City of Albuquerque Stormwater Construction Site Inspection Report

Project Name and Location	A.I.S. Refail 1st and Indian School		
Site Contact Name & Agency	Joe Aguirre Klinge Construction	Contact Phone #	270-6711
Date of Inspection	7-26-16	Start/End Time	10:45 / 10:55
Inspector Name, COA Dept.	Curtis Cherne, Stormwater Quality		
Inspector Phone / E-mail	505-924-3420/ccherne@cabq.gov		
Inspector Qualifications	Qualified Compliance Inspector of Stormwater- Stormwater One		
Describe Present Phase of Construction	Stabilized

A.I.S. RETAIL
EROSION & SEDIMENT CONTROL

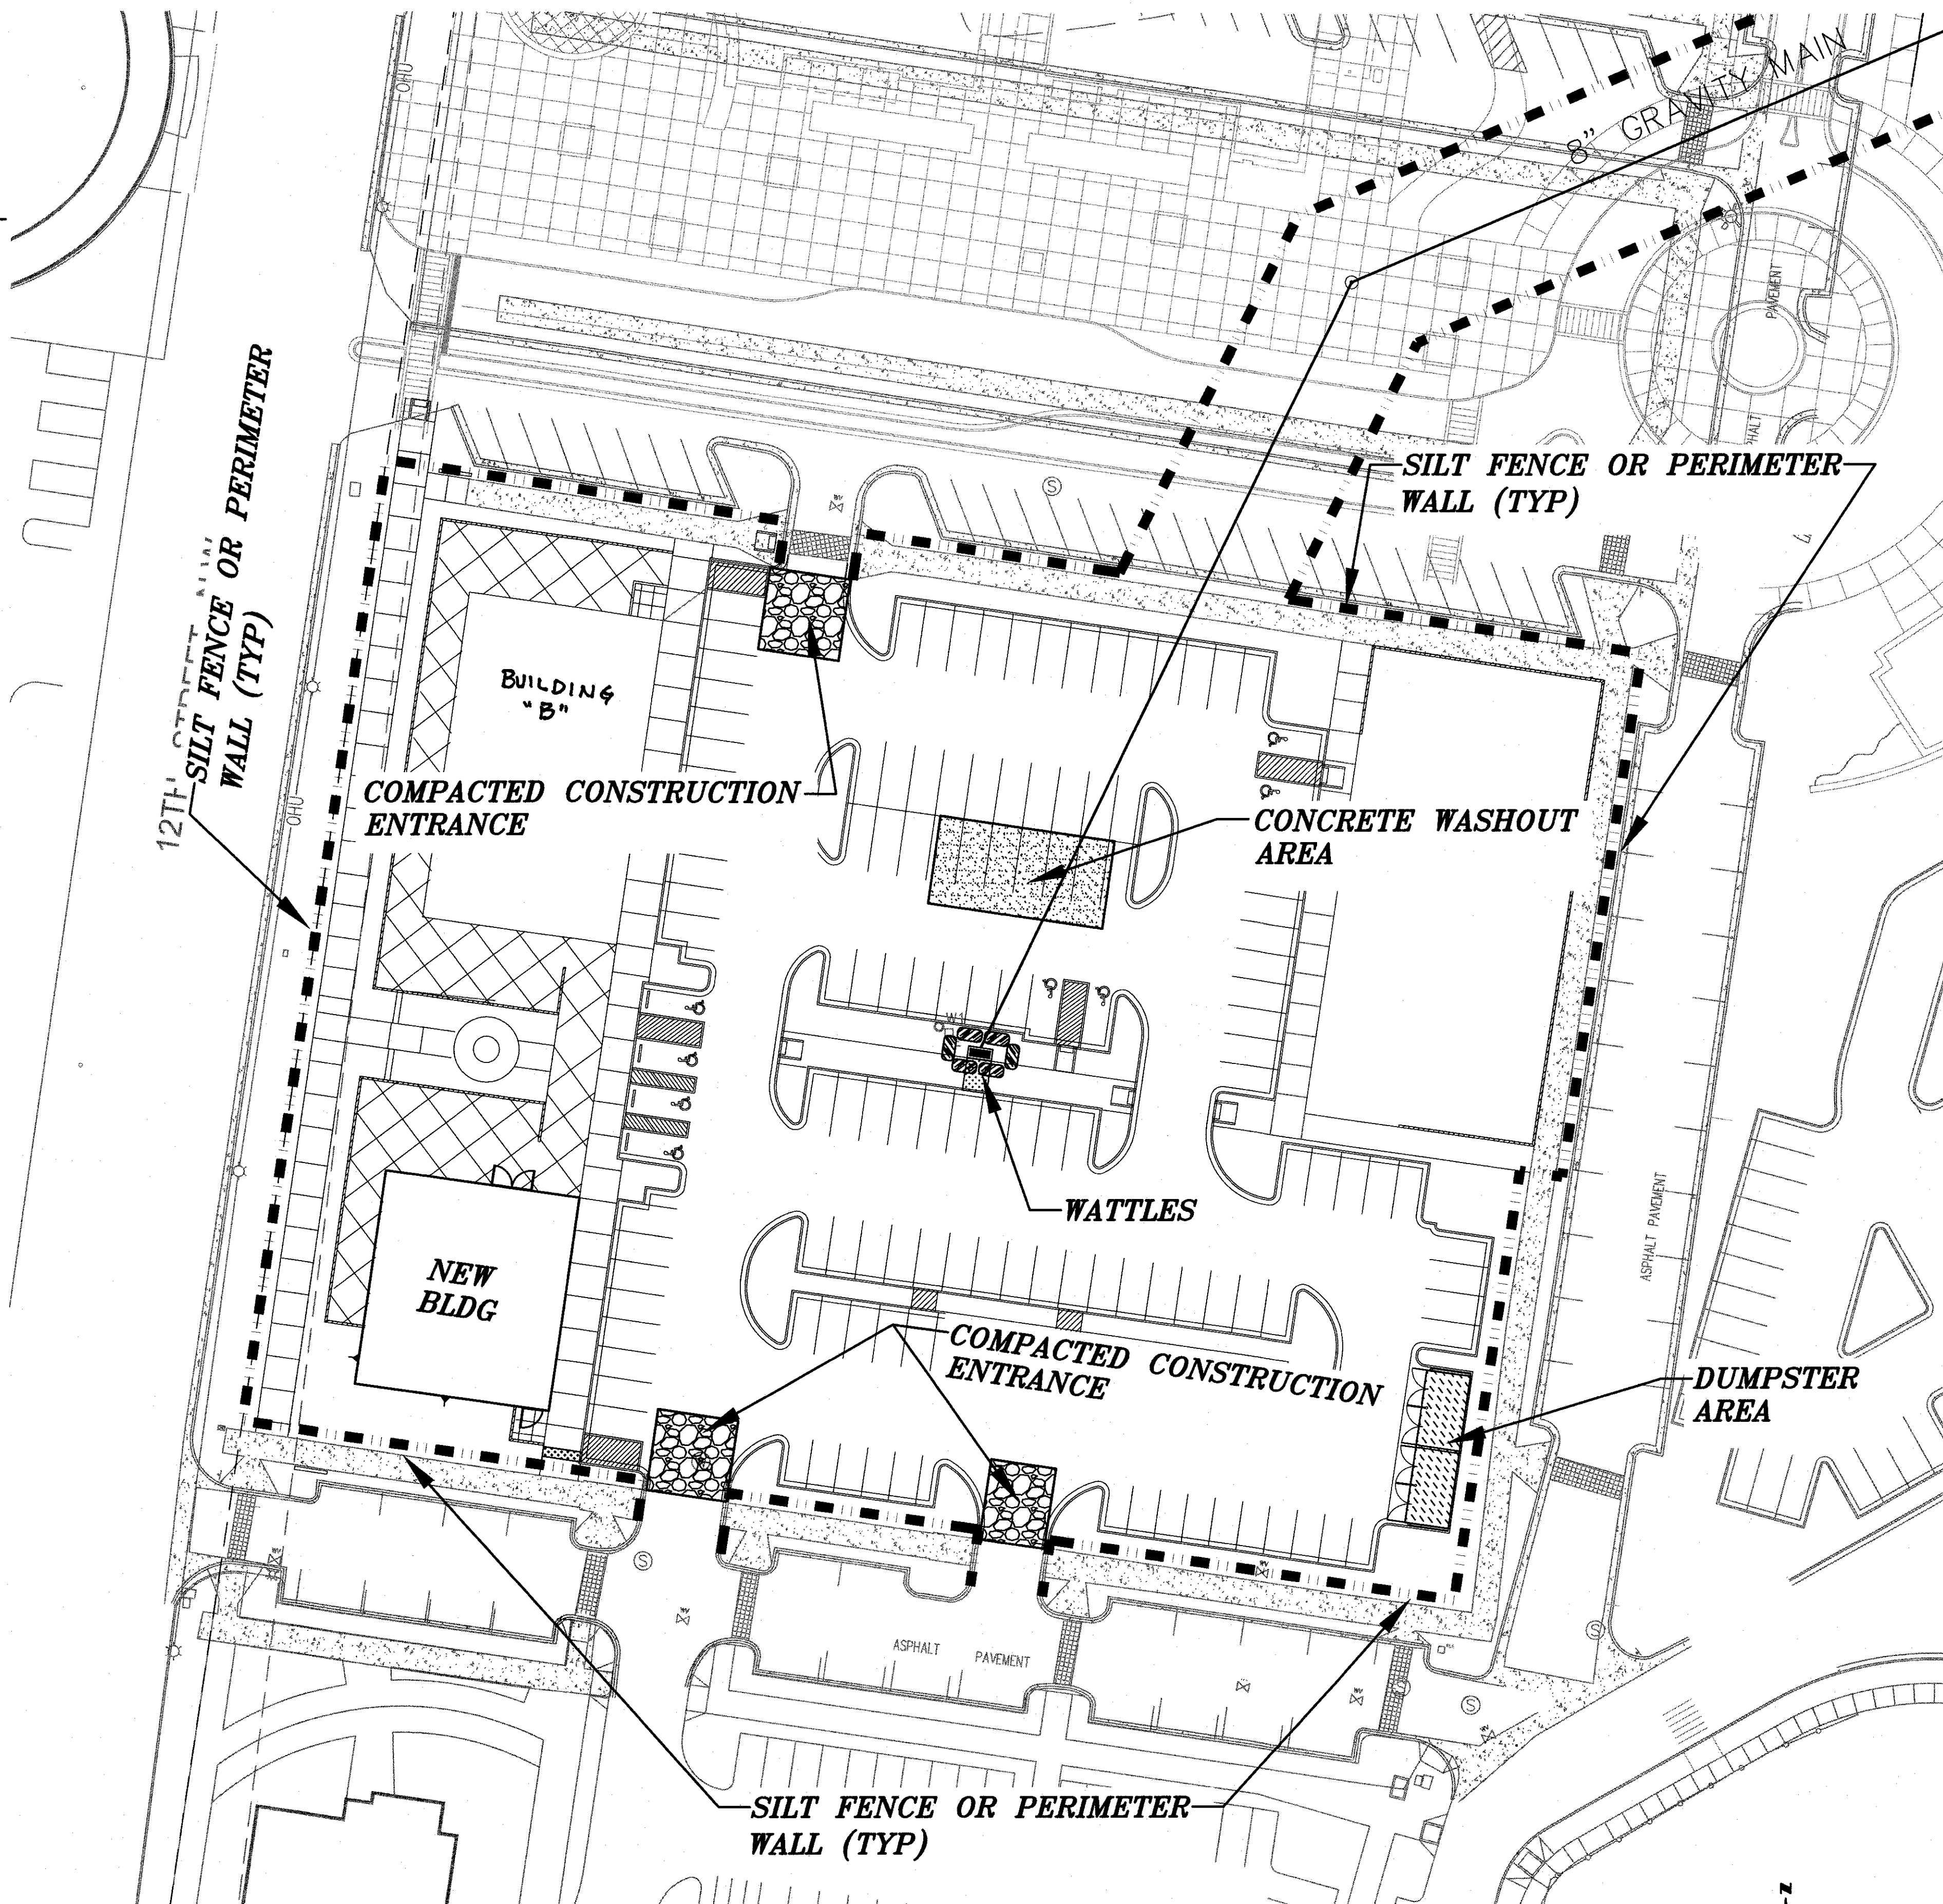
- Entrance / Off Tracking entrance needs maintenance, minor track off
- Sediment Controls / Silt Fence, Check Dams, Waddles, etc. inlet missing inlet protection
- Erosion Controls / Mulch, Seed, NO
- Wind Blown Erosion NO
- Housekeeping / Pollutant Controls Very good
-

Is site being maintained in compliance with Const. Gen. Permit ? • Yes • ☒ No
